**DELEGATED DECISION FOR APPLICATION FOR CERTIFICATE OF
LAWFUL DEVELOPMENT**

Reference no.: 2021/CL/94398/E

Site: 11, Squirrel Walk, Dewsbury, WF13 4AQ

Description: Certificate of lawfulness for proposed alterations to
roof and erection of rear dormer extension

PROPOSED FLOOR PLANS & ELEVATIONS

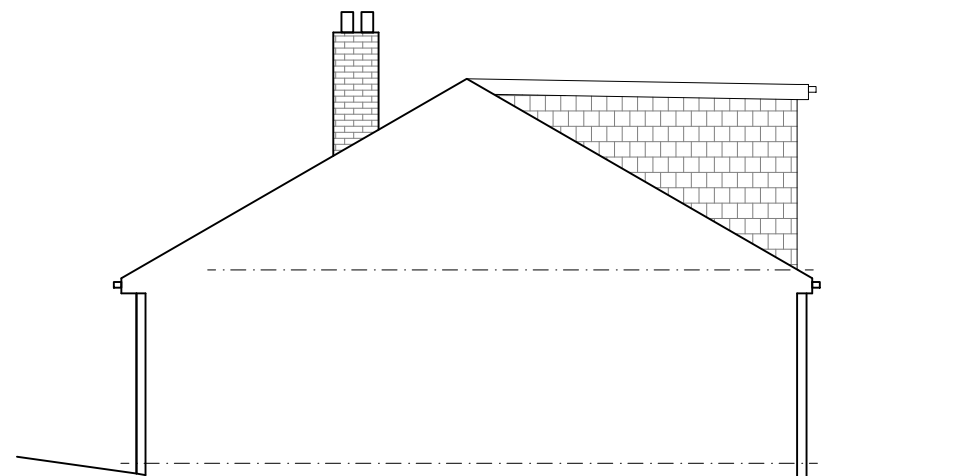
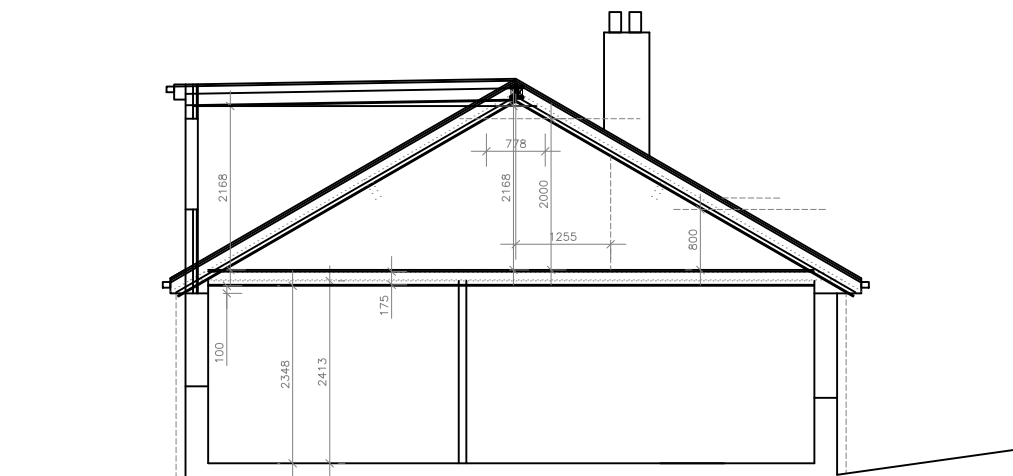
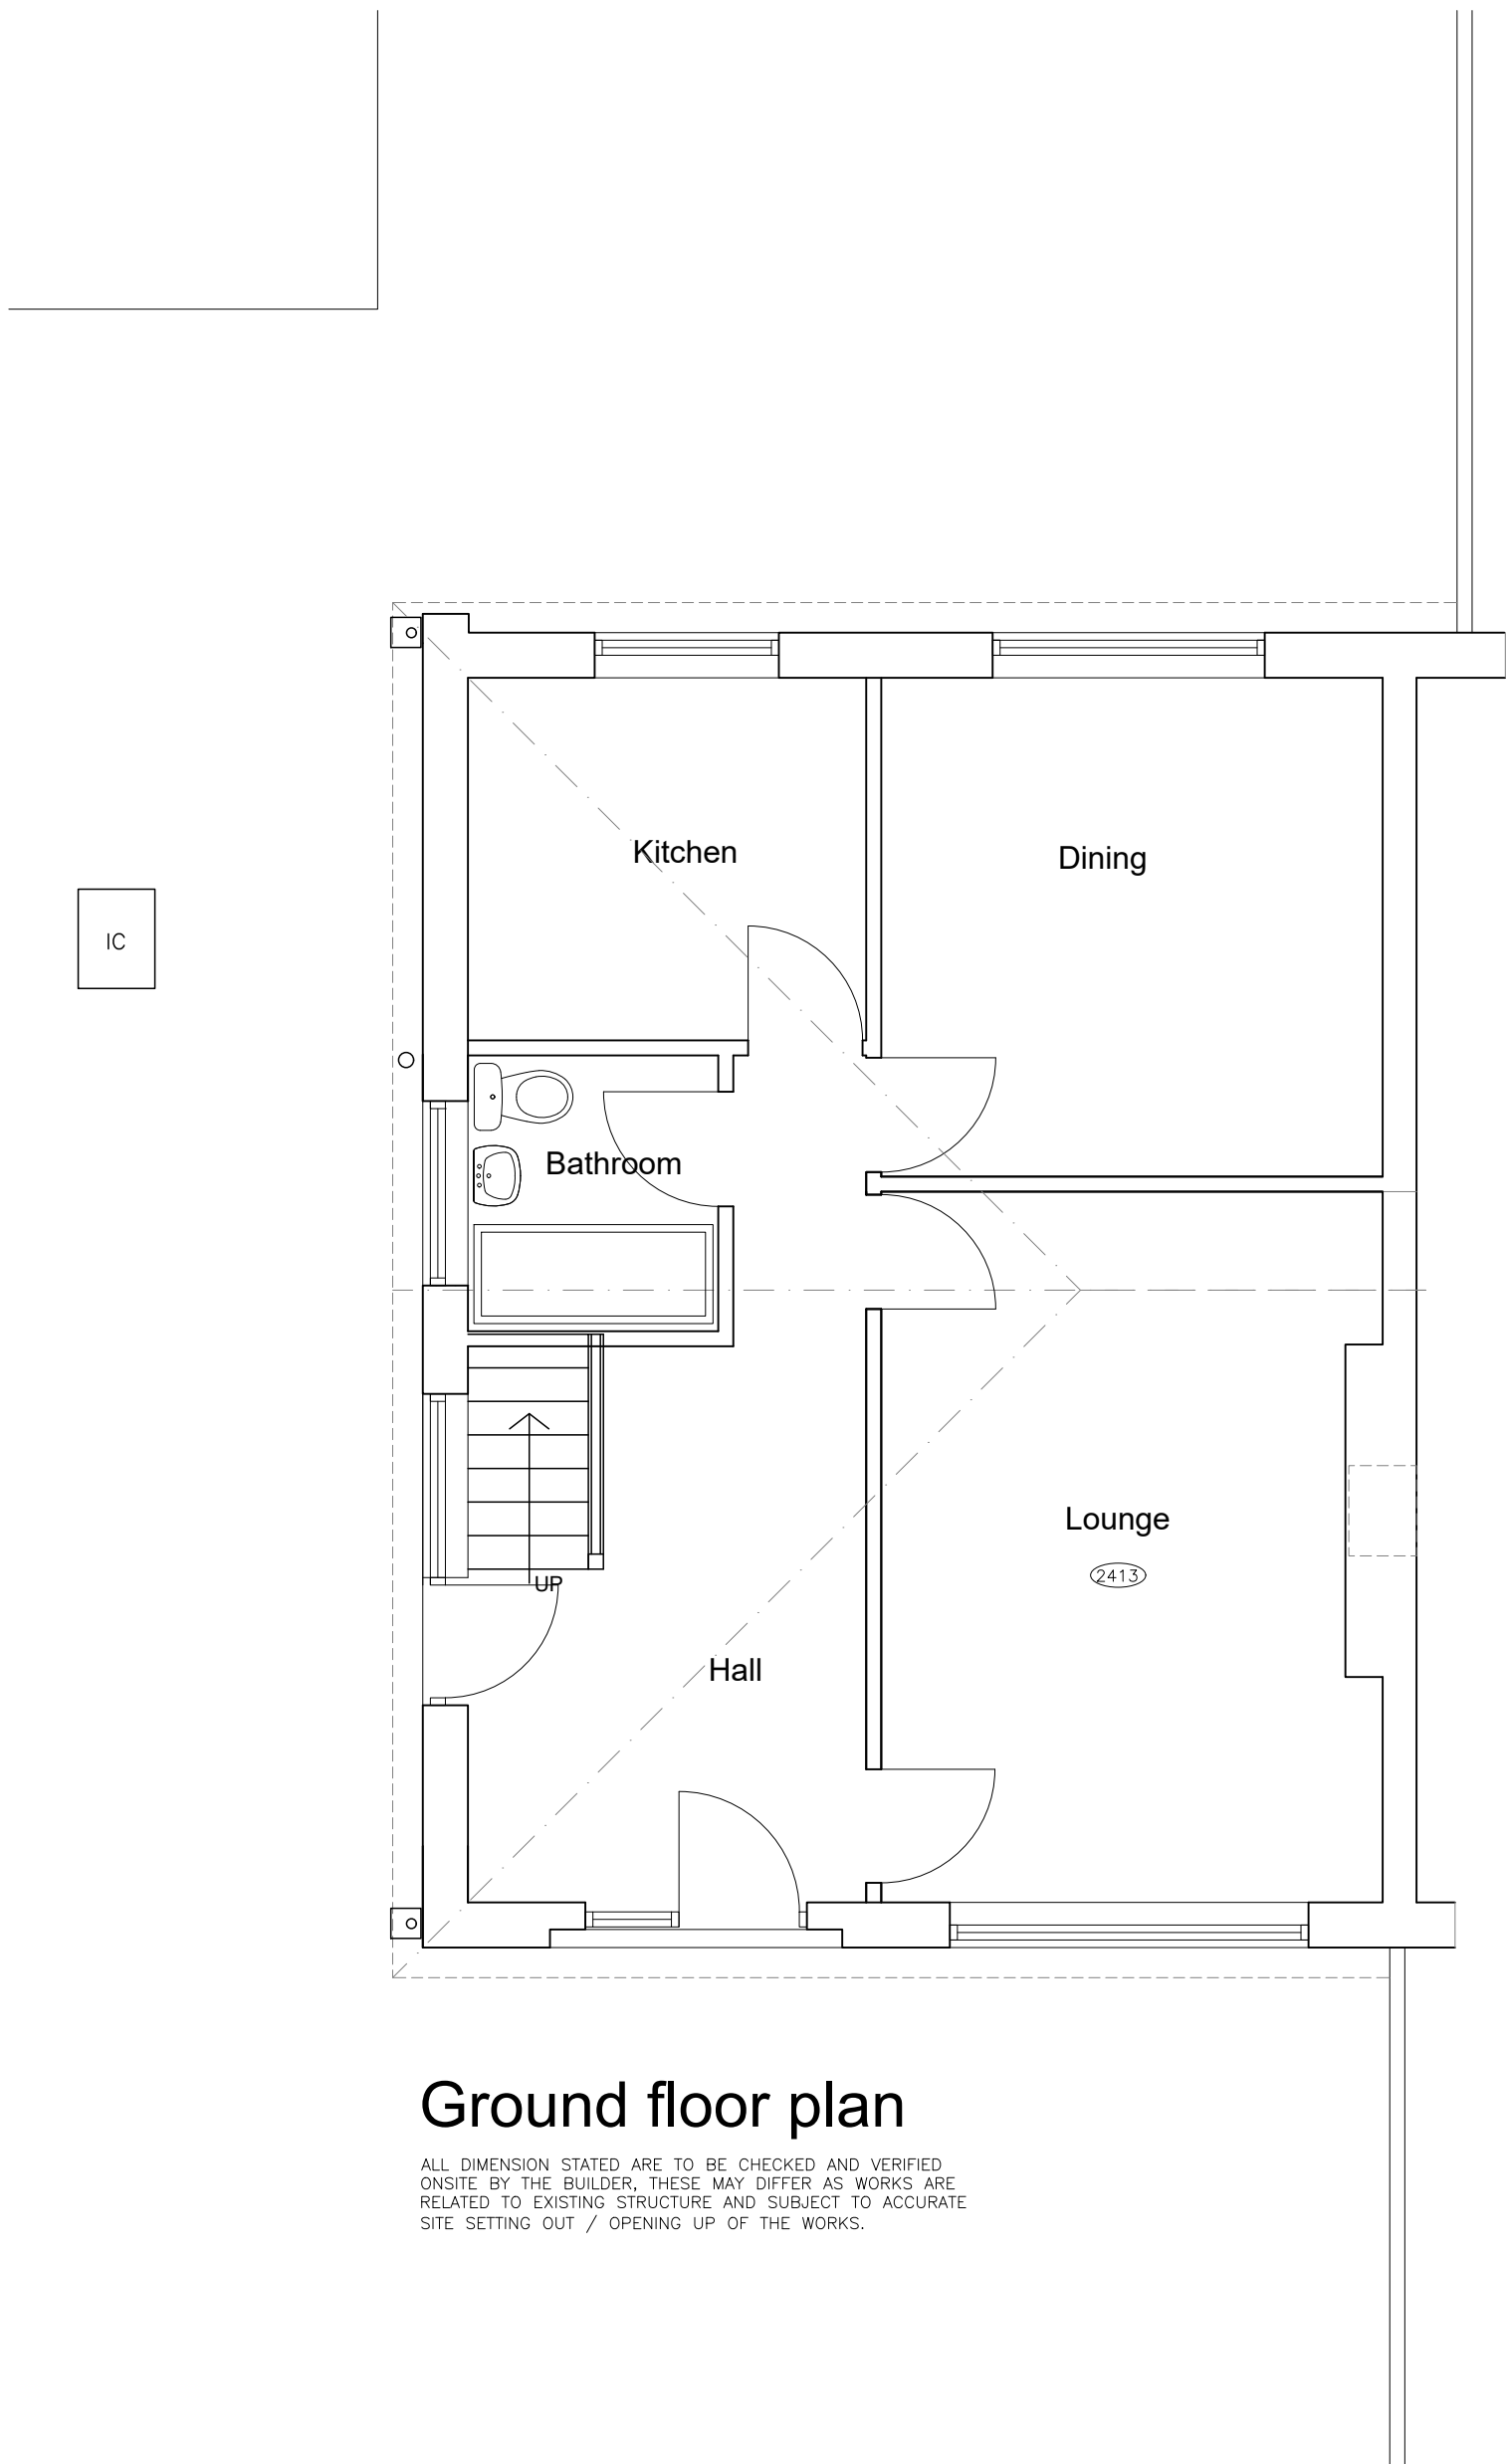
Comment: *The height of the highest part of the existing roof would not be exceeded by the proposals.*

Comment: *The proposed hip to gable roof conversion and rear dormer extension would not extend beyond the plane of any existing roof slope forming the principal elevation of the dwellinghouse and which fronts a highway.*

Comment: *The enlargement of the roof space involves the following:-*

Dormer = $(6.3\text{m} \times 2.4\text{m} \times 4.3\text{m})/2 = 32.5$ cubic metres

Hip to Gable = $(8.8\text{m} \times 4.2\text{m} \times 2.6\text{m})/6 = 16.0$ cubic metres

TOTAL = 48.5 cubic metres

Comment: *Approval is granted subject to the above conditions.*
